Ribble Valley Borough Council
By email

Your ref 3/2024/0484
Our ref DC/24/2254
Date 06-NOV-24

Location: Ramsgreave Bakery Pleckgate Road Ramsgreave BB1 8QW

Proposal: Proposed demolition of existing warehouse structure and erection of two separate blocks of industrial units comprising one block of five units, each with a mezzanine floor and one block of two units each with a mezzanine floor, including associated car parking and service yard

Existing Section BB, scale 1=200

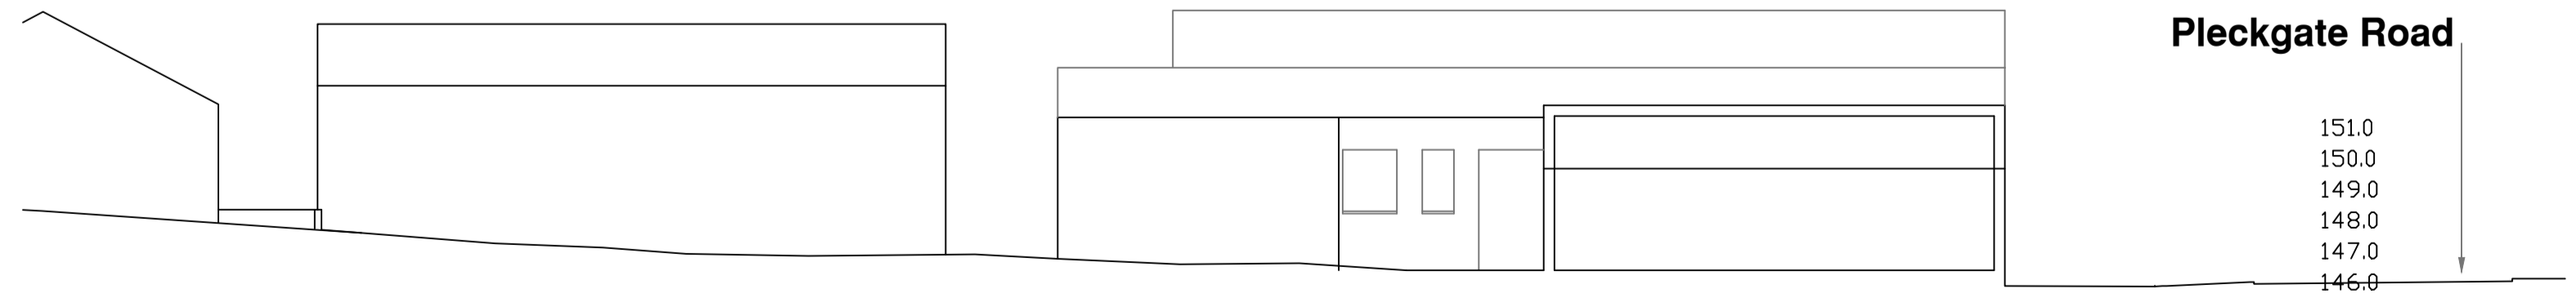
Noting this is a Full application, we request that the applicant provides a detailed drainage plan, and that United Utilities has the opportunity to review and comment on this plan PRIOR TO DETERMINATION of this application.

A water main is located in the vicinity of the site red boundary. It must not be built over, or our access to the pipeline compromised in any way. We require an access strip as detailed in our 'Standard Conditions for Works Adjacent to Pipelines', which can be found on our website: <https://www.unitedutilities.com/builders-developers/your-development/planning/building-over-or-working-near-our-assets/working-near-our-pipes/>. The applicant must comply with this document to ensure pipelines are adequately protected both during and after the construction period.

A public sewer crosses the site and we will not permit building over it. We require an access strip for maintenance or replacement and this access must not be compromised in any way. The minimum distances that might be acceptable to United Utilities are detailed within Part H of the Building Regulations however, we recommend the applicant determines the precise location, size, depth and condition of the pipeline as this is likely to influence the required stand-off distance from any structure.

Prior to the commencement of development, details of a sustainable surface water drainage scheme and a foul water drainage scheme shall be submitted to and approved in writing by the Local Planning Authority. The drainage schemes must include:

- (i) An investigation of the hierarchy of drainage options in the National Planning Practice Guidance (or any subsequent amendment thereof). This investigation shall include evidence of an assessment of ground conditions and the potential for infiltration of surface water in accordance with BRE365;***
- (ii) A restricted rate of discharge of surface water agreed with the local planning authority (if it is agreed that infiltration is discounted by the investigations);***

- (iii) Levels of the proposed drainage systems including proposed ground and finished floor levels in AOD;*
- (iv) Incorporate mitigation measures to manage the risk of sewer surcharge where applicable; and*
- (v) Foul and surface water shall drain on separate systems.*
